PROJECT NO. PR-2020-005492

Application No. SI-2021-01694

Memorandum

To: Jolene Wolfley and DRB Members, City of Albuquerque
From: Michael Vos, AICP, Consensus Planning, Inc. *MV*
Date: November 5, 2021
Re: Ladera RV & Boat Storage Comment Responses (PR-2021-005492)

PROJECT NUMBER: PR-2021-005492  
 Application Number: SI-2021-01694

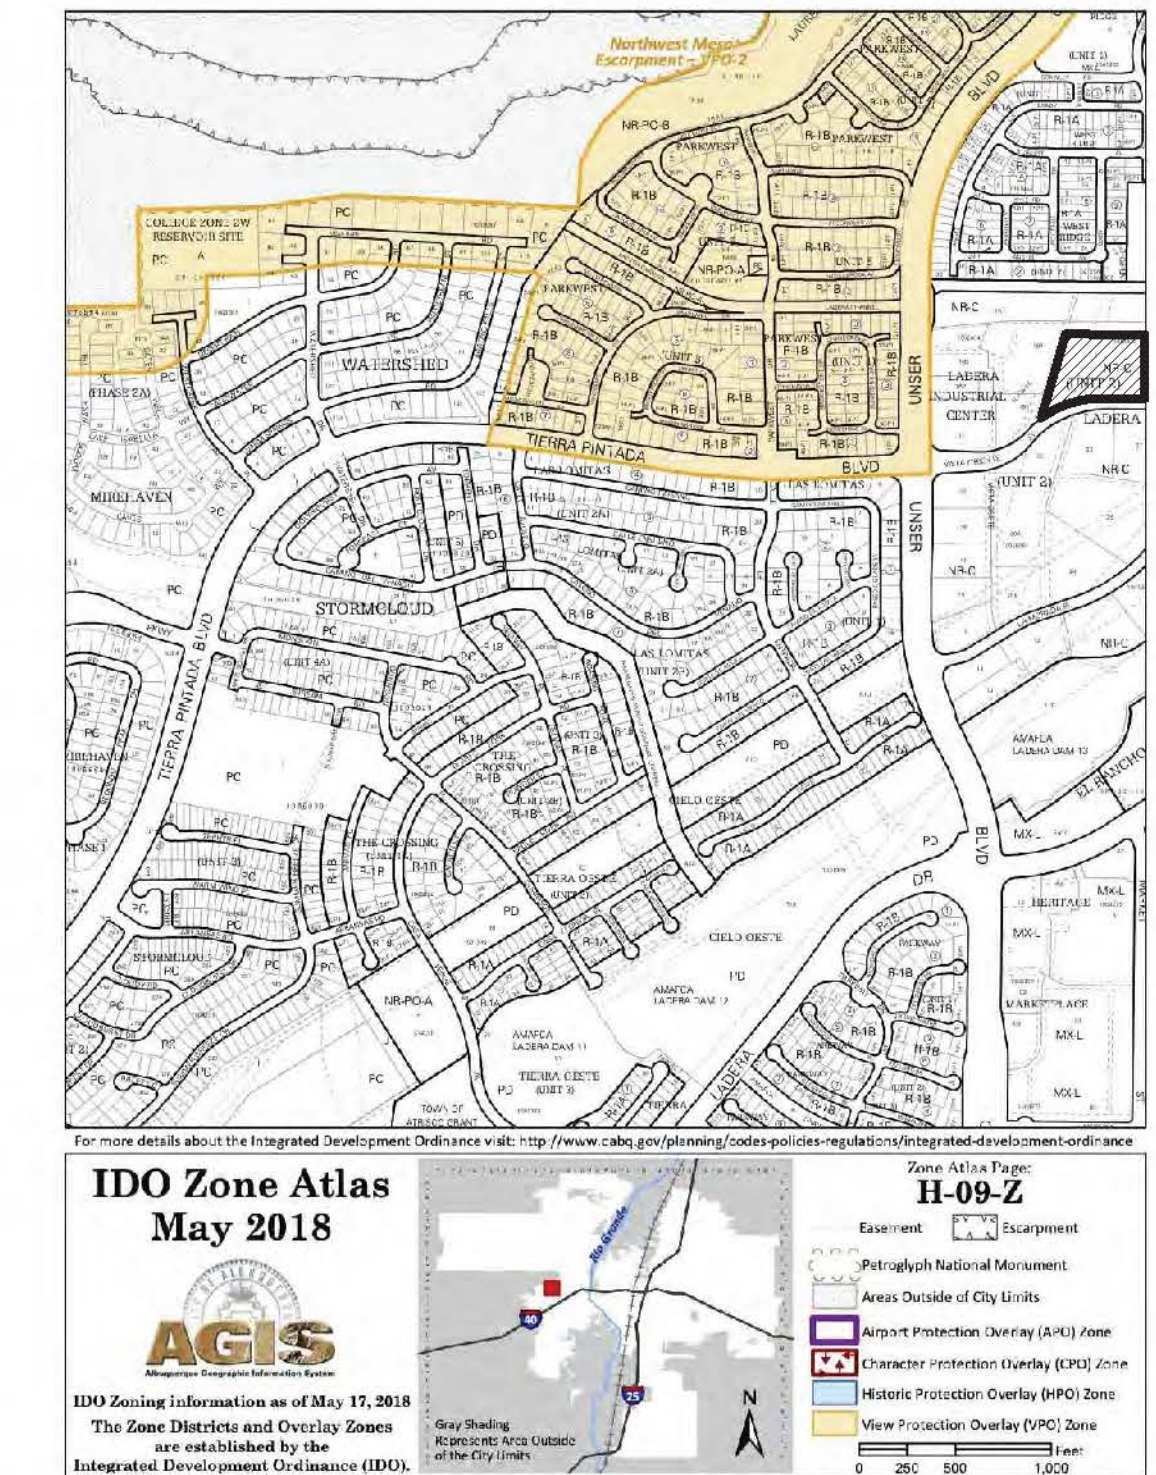
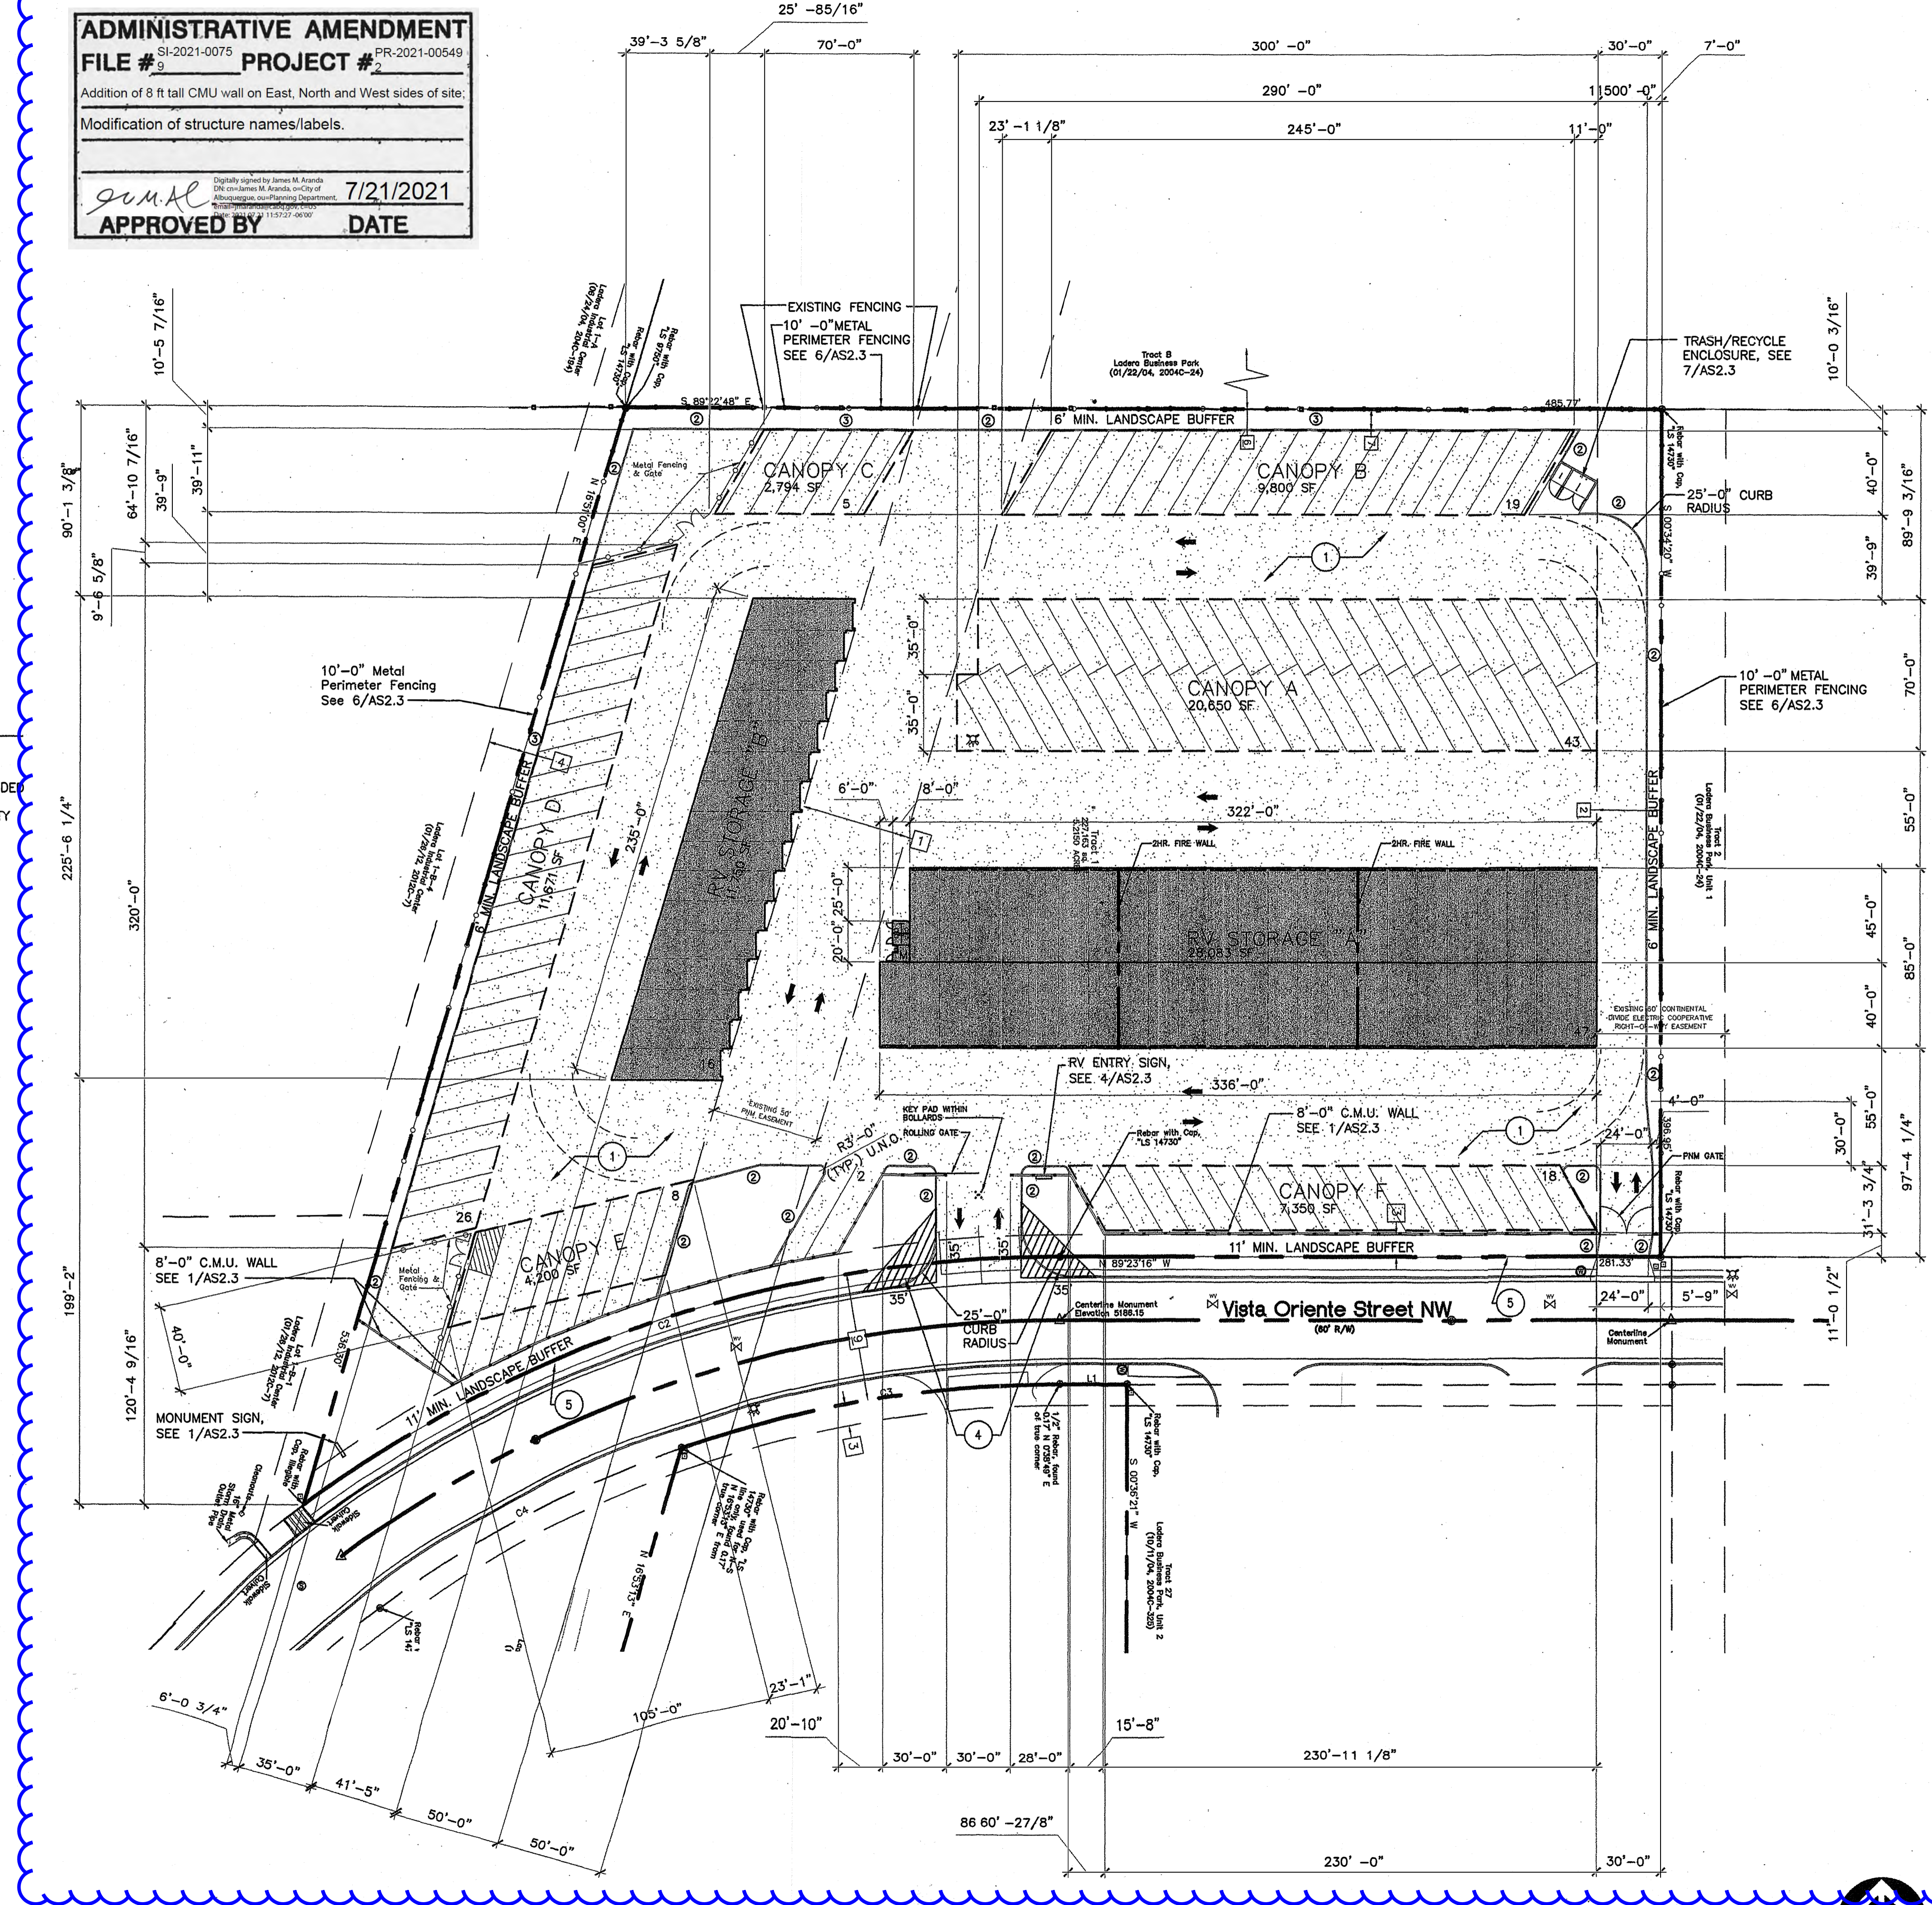
The Project Architect has clarified the proposed uses of the buildings and structures on the plan to reflect both outdoor and indoor RV storage spaces along with the proposed RV park spaces.

Per correspondence with Transportation staff, since this is an amendment to an existing plan (that is being constructed per the original approval), and access is from a local street, a turnaround will not be required to be added at the entrance. The other requested dimensions and sidewalk have been added to the plans.
